Proposed Marine Energy Park, Killingholme

Summary of Oral Representations by Associated British Ports at HRA/Ecology Hearings

11th and 12th September 2012

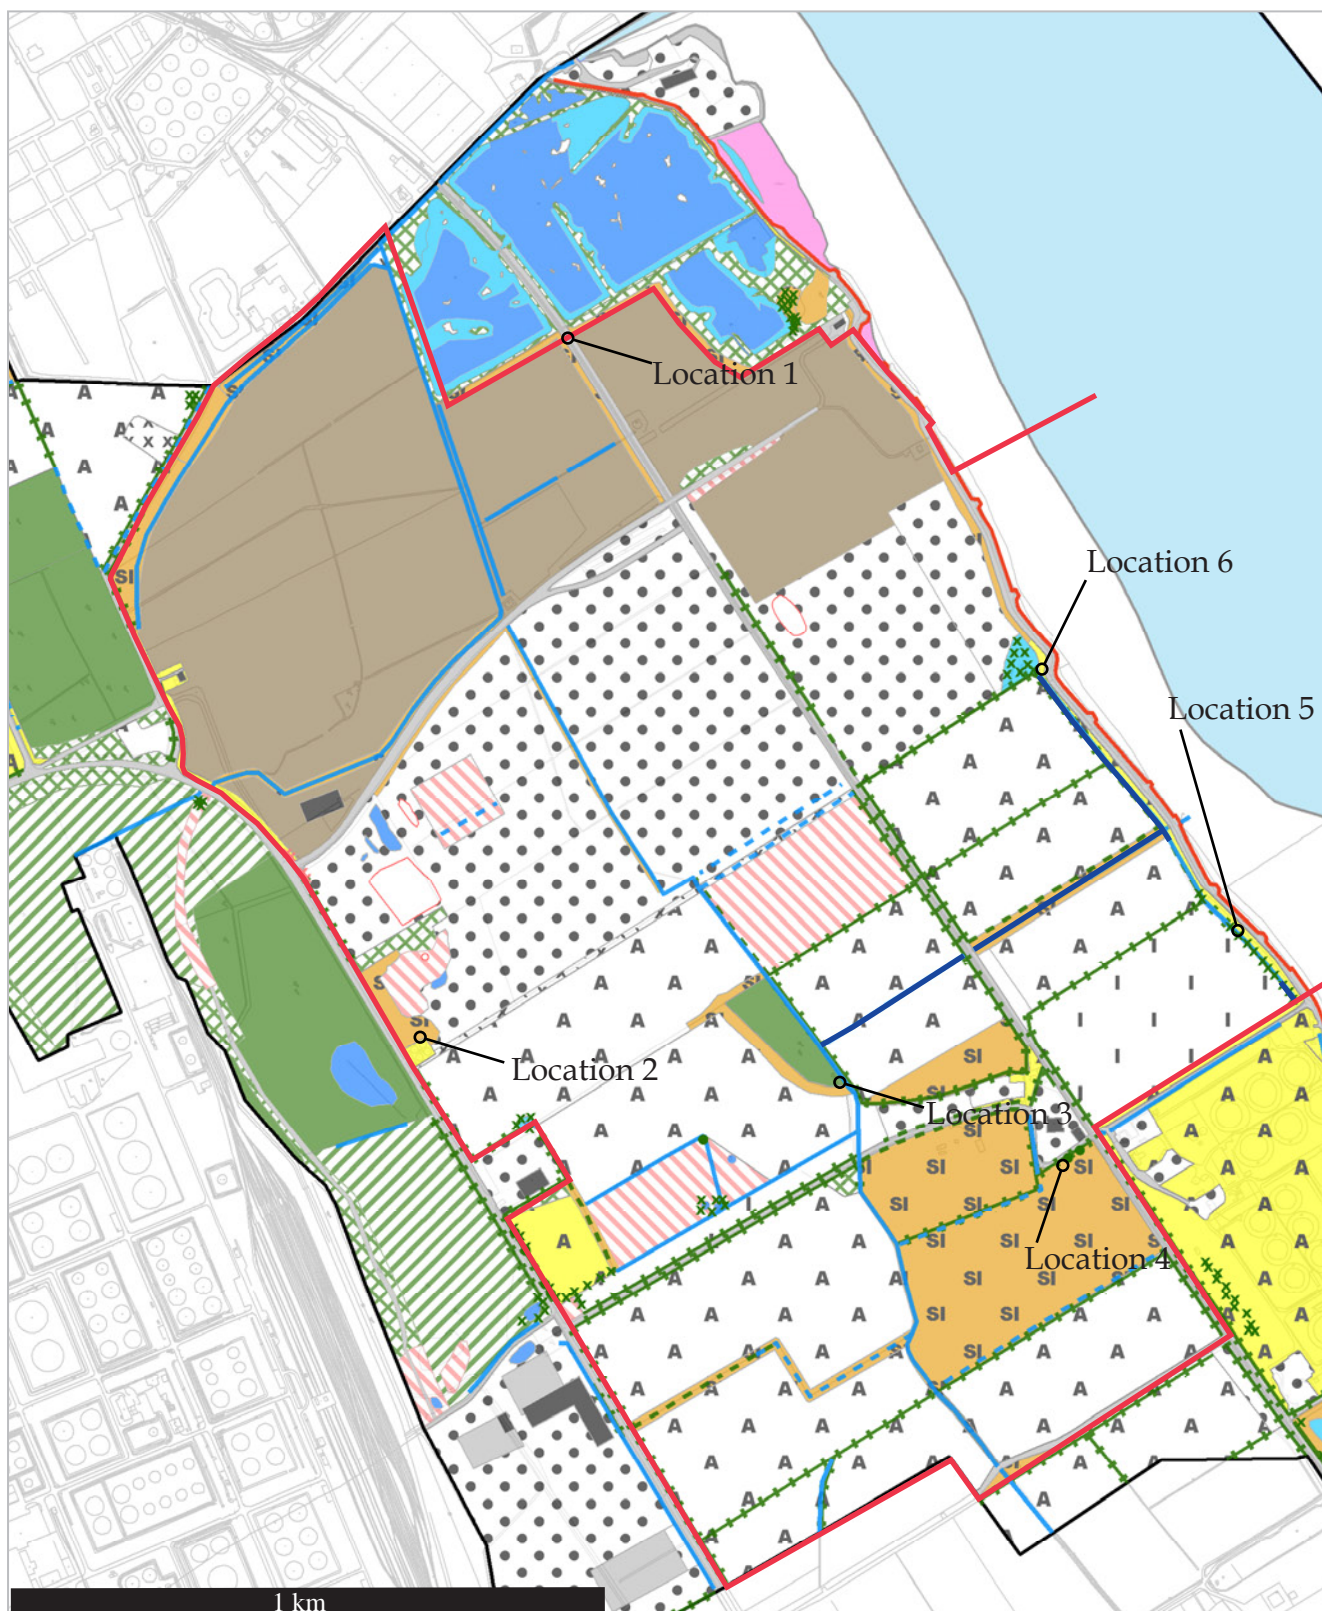
3.1 The scoping report produced by Just Ecology in 2006 (Annex 11.1) highlighted the need to carry out further ecological surveys (para 8.1.1) including *'foraging transects'* (bullet point 6, arrow point 3 on page 44). **No transect surveys of the site have been completed.** The bat surveys that were carried out in 2010 (Annex 11.3), rather than carrying out a walked transect, adopted an unusual survey method of placing remote bat detectors at six locations across the site on only two occasions (July 24th and August 24th 2010) on one of which the detectors had to be removed due to the prospect of rain.

- 7.1 ABP noted that both the 2010 and the 2011 surveys had **used equipment that was out of date**. Mr Hatton (for Able) appeared to misunderstand the point being made to him since he referred in his oral evidence to the difference between the Anabat SD1 and SD2 models. The point actually being made concerned the fundamental change in bio-acoustic equipment since 2009. In summary, in 2009 a new kind of remote bat detector was introduced to the UK that uses 'full spectrum' recording rather than 'zero crossing'. The advantages of full spectrum over zero crossing are well documented both by peer review and grey literature. For various reasons full spectrum recording is much more effective and provides considerably more data than zero crossing.

- 7.3 In line with the BATNEEC principle (Best Available Technique Not Entailing Excessive Cost) the new equipment is now used by the vast majority of ecologists and has become the industry standard. **It should have been used in the 2010 and 2011 survey work, but was not. Instead, Anabats, with all their various deficiencies, were used.**

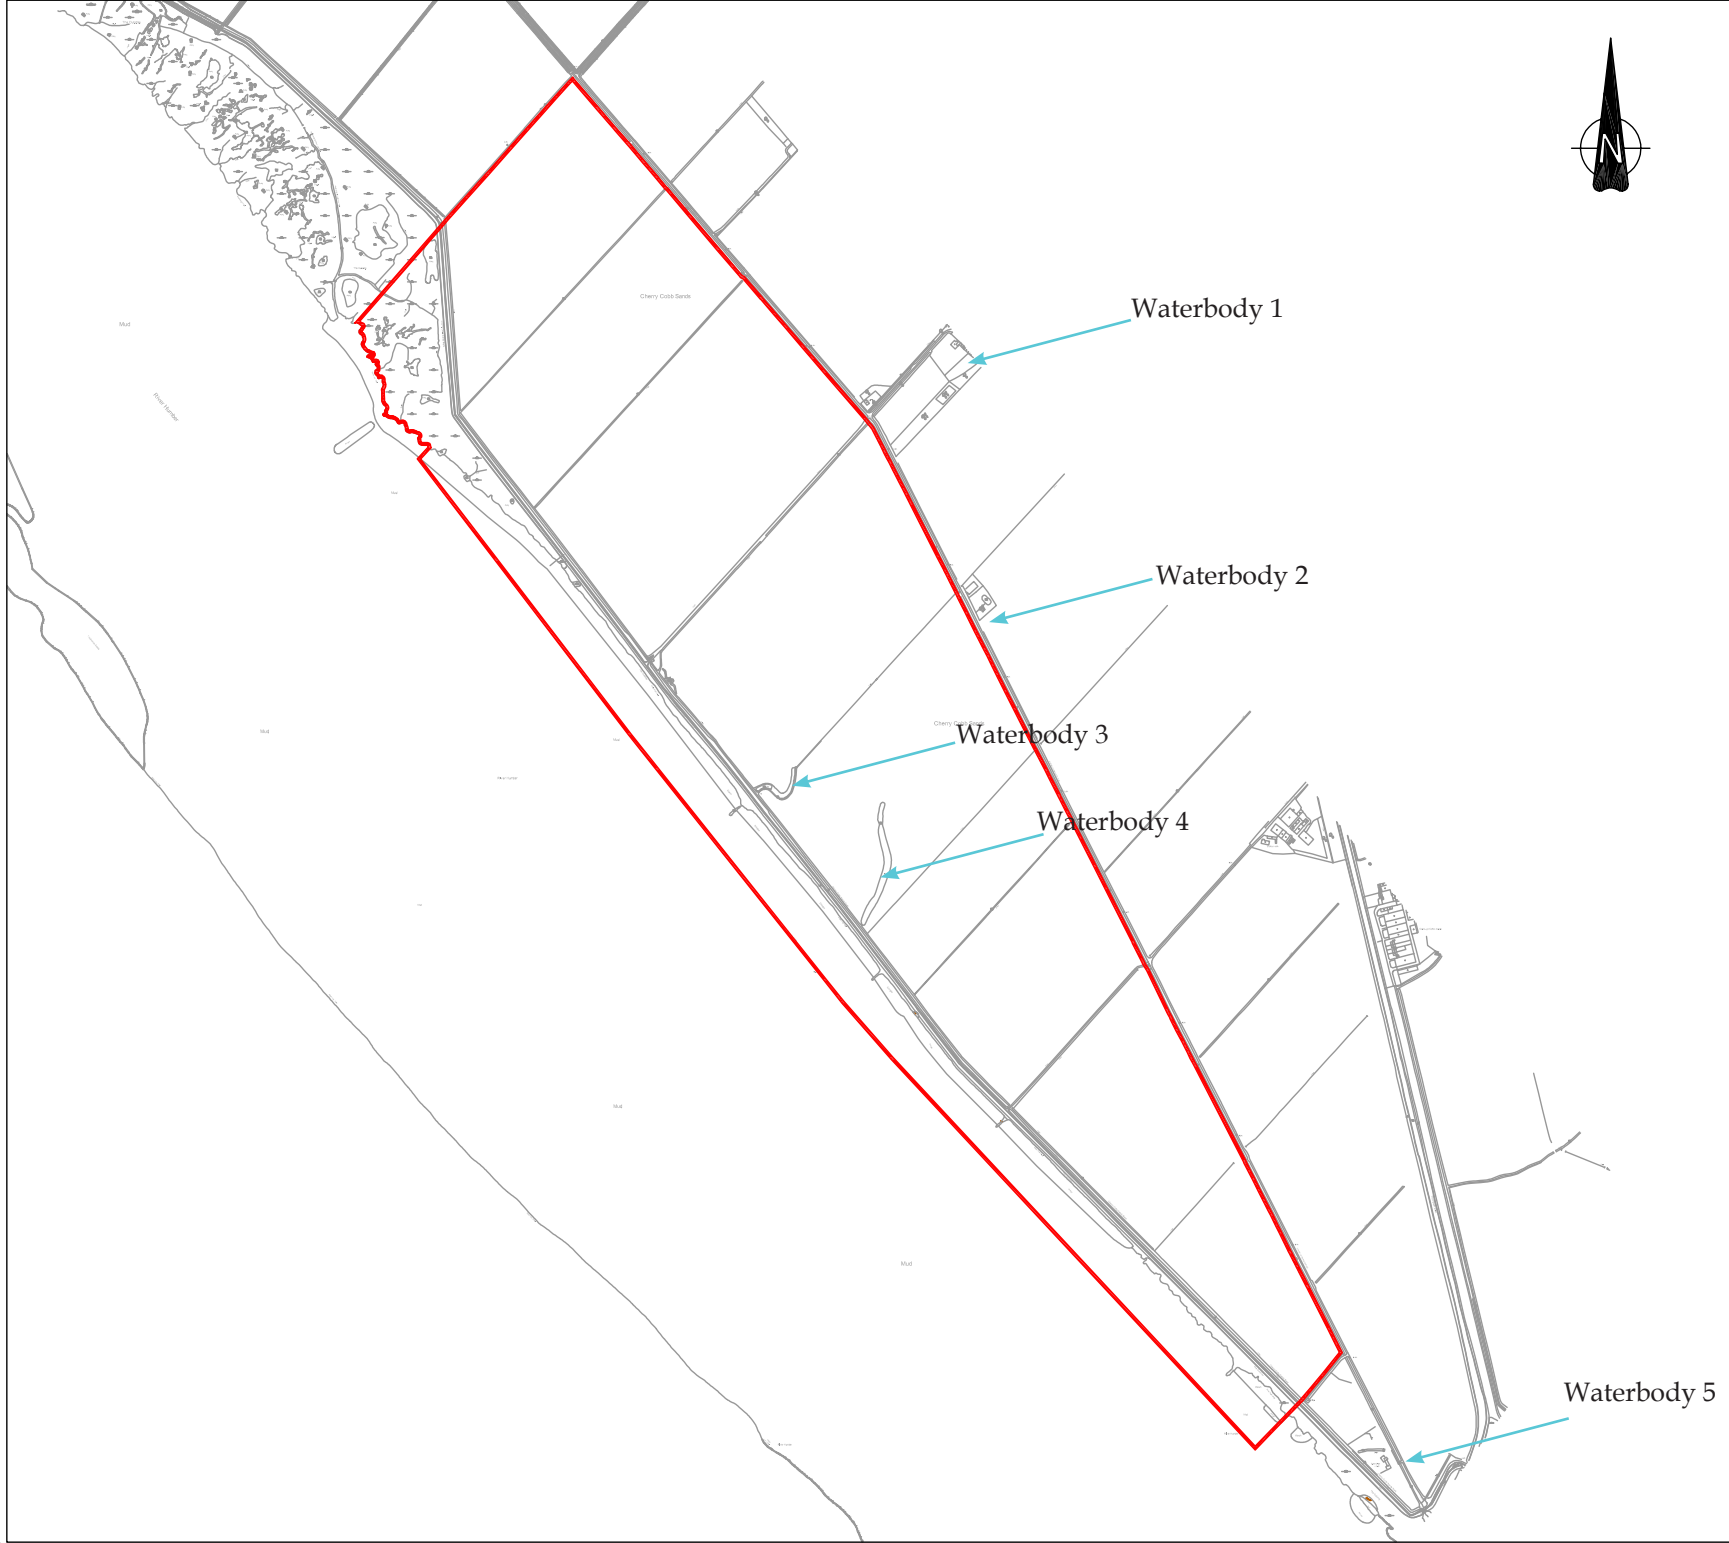
- 5.6 Furthermore many of the trees identified as having bat roost potential are outside Old Copse (see Annex 11.8, Figure 1). **These trees were not subjected to any further activity survey**.

- 5.7 Turning to the results of the 2011 survey **the interpretation is clearly incorrect**. Paragraph 3.2.5 describes how a *Nyctalus* sp (Noctule/Liesler's) bat was recorded 20 minutes after sunset. Noctule bats generally emerge soon after sunset however there are many reasons why emergence can be delayed and indeed the published research shows an emergence time of between 0 and 40 minutes after sunset (Racey, 1991; Russ, 1999). **It is therefore unreliable to assume that a Noctule bat recorded 20 minutes after sunset was not roosting in the locality** – especially when the bat in question was not seen as is the case here.
